Proposed Residential Development Mortimer Road Cubley Access Appraisal

Our ref 5212/JGM/01

November 2008

Drawing Title
VISIBILITY AVAILABILITY FROM
PROPOSED SITE ACCESS

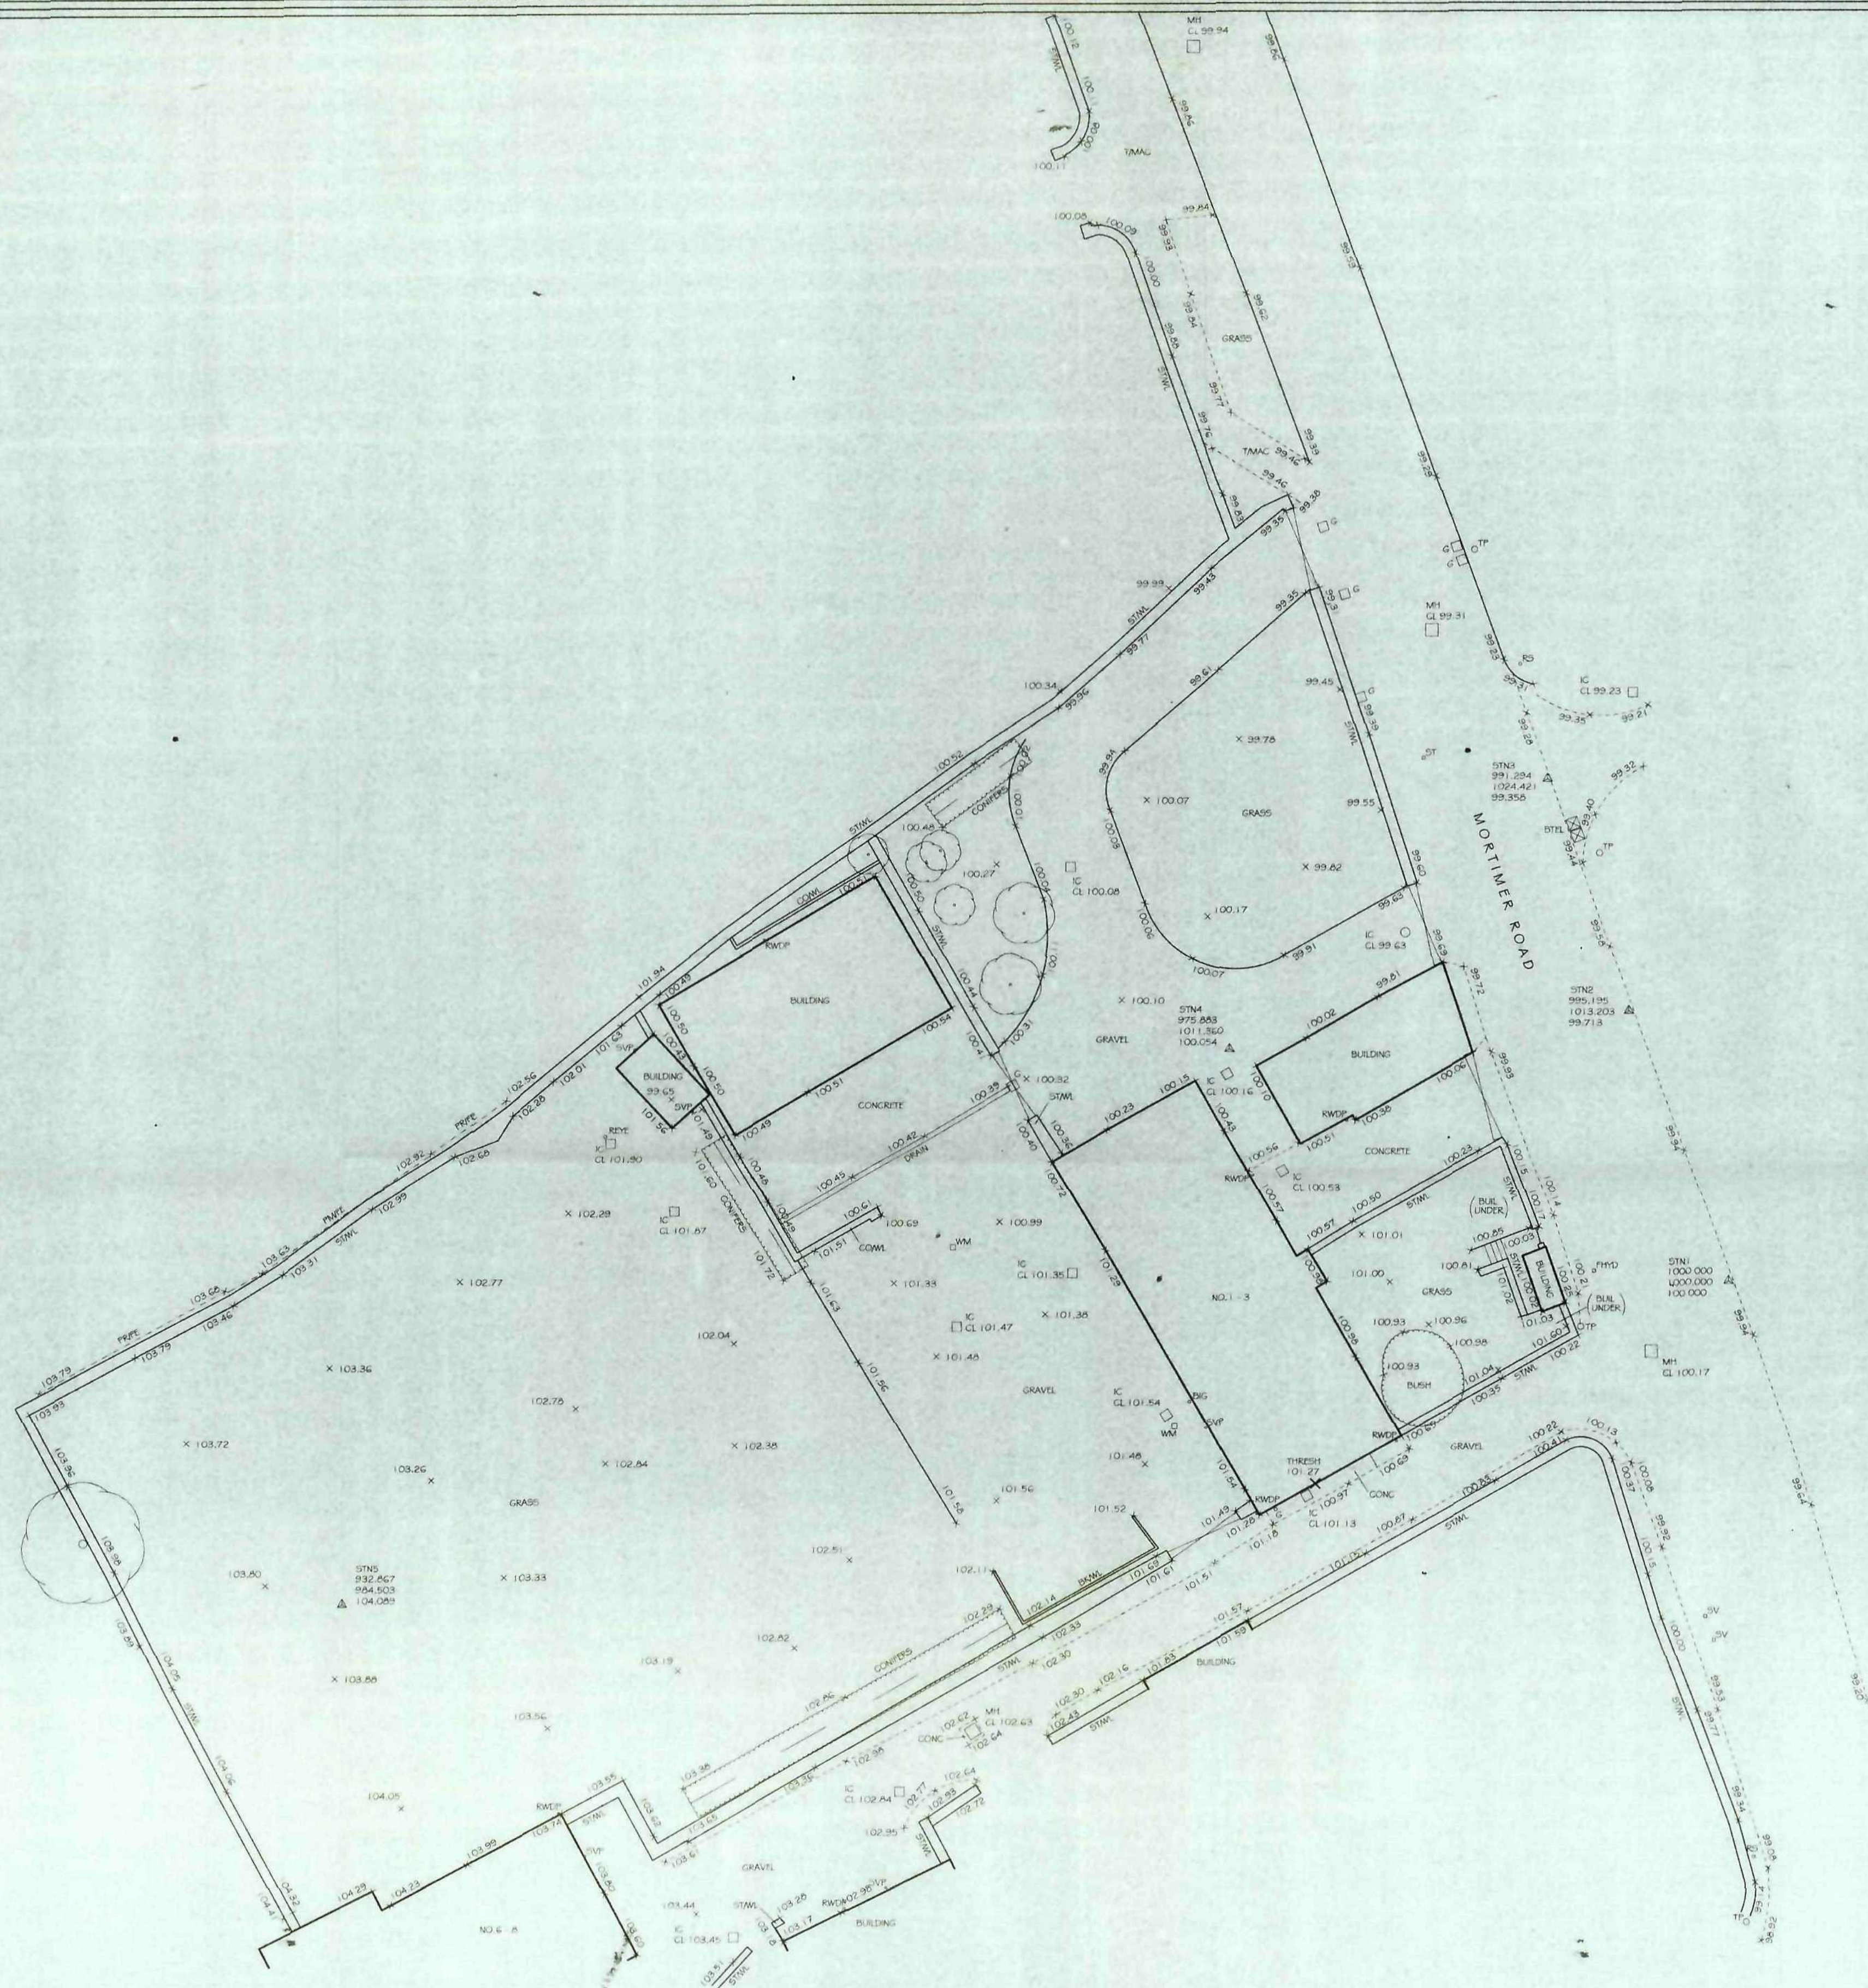
- *The site is just inside the 30mph limit and vehicles can approach the site from the south at up to 60 mph: the standard visibility requirements for 60mph is 215m.*
- *I require to see a drawing showing that the claimed visibility splays can be achieved using only land which is under the control of the applicant, or is highway land.*
- *The drawing 'SITE PLAN no P/3/7' appears to show a 2m footway provided with the kerbline further forward than the present edge of carriageway. Given the substandard width of the existing carriageway of Mortimer road, this is completely unacceptable. I note that there is not a footway as such at present on the site frontage, but there is a shoulder at the same level as the carriageway, which must be retained.*

- 3.6 The information detailed in the tables above indicates a significant difference in the visibility requirements for the 85th Percentile wet weather speed recorded for north and south bound traffic. The table below indicates the available visibility in accordance with the proposed site access:

Table 3.6 (a) Available Visibility

Right Visibility	SSD + 2.0m	SSD + 2.4m
Left	100.00>	100.00>
Right	66.08	58.23

- 3.7 As can be seen from the table above the level of visibility to the left exceeds the requirements for both MfS and DMRB, visibility to the right does not meet with DMRB and is slightly substandard in comparison to MfS. However it should be recognised that the proposed access offers a significant improvement on the existing situation.
- 3.8 As previously mentioned the number of vehicular access points will be reduced to one centralised access, a 2.0m footway will also be provided within the site boundary to improve pedestrian access to the site and visibility.
